**MP 10_0171 Mixed Use Residential, Retail and Commercial Development at 330
Church Street, Parramatta**

I refer to the proposed development at the above address and submit the following comments on behalf of Parramatta Park Trust.

FROM GOV. HOUSE
25 / 05 / 11
ME 4250

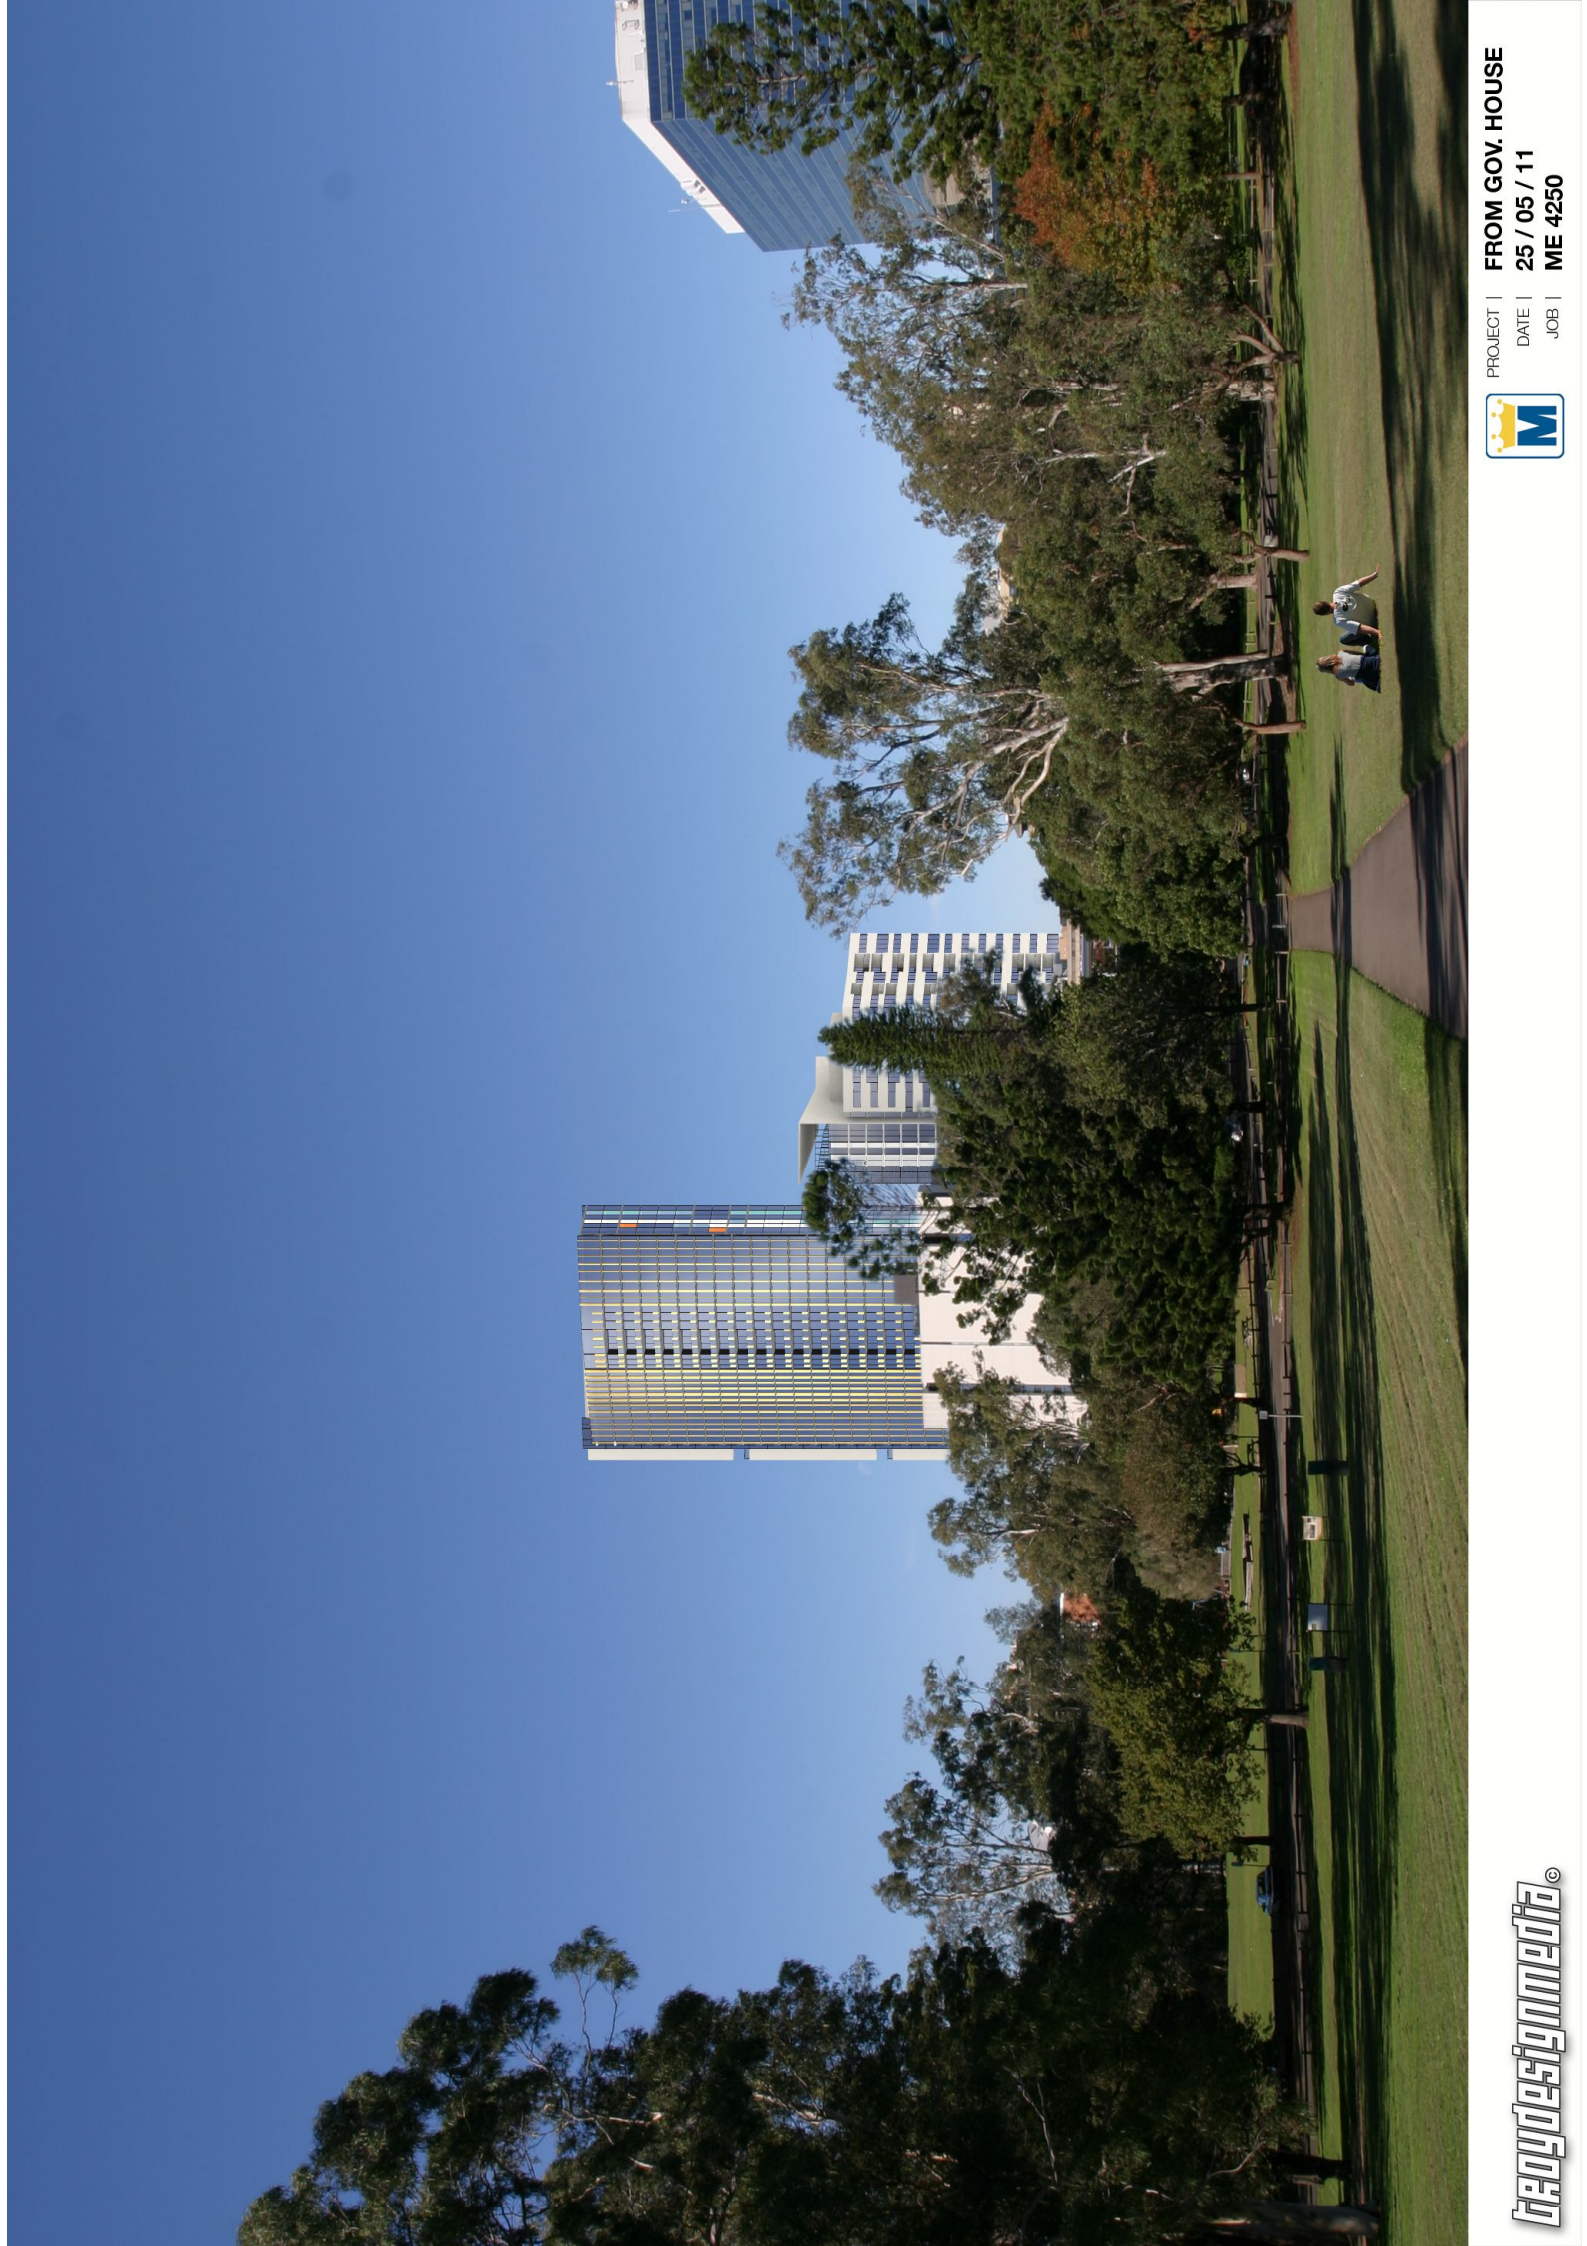
The impact of the proposed development on OGHD is extensive as can be seen from the attached views (see attachment C). The authenticity and integrity of OGHD arises from its historical/functional role as the seat of government authority - the earliest remaining public building in Australia and its landscape setting - overlooking Parramatta, with views across the city and historic Parramatta River to the hills beyond. The heritage significance of these views is well documented. The proposed building is not consistent with these values.

There is no evidence in the proposal that the applicant has considered the height impact on OGHD.

1. Instructs the proponent to revise the Statement of Heritage Impact and the Visual Impact Assessment Report for the development to assess the impact on the heritage values of Old Government House and Domain site arising from the proposal.
2. Invites Parramatta Park Trust and the National Trust of Australia (NSW) to make a further submission once the Statement of Heritage Impact and the Visual Impact Assessment Report have been revised.
3. Instructs the proponent to refer the proposed development for assessment pursuant to the Environment Protection and Biodiversity Conservation Act 1999 (the EPBC Act);
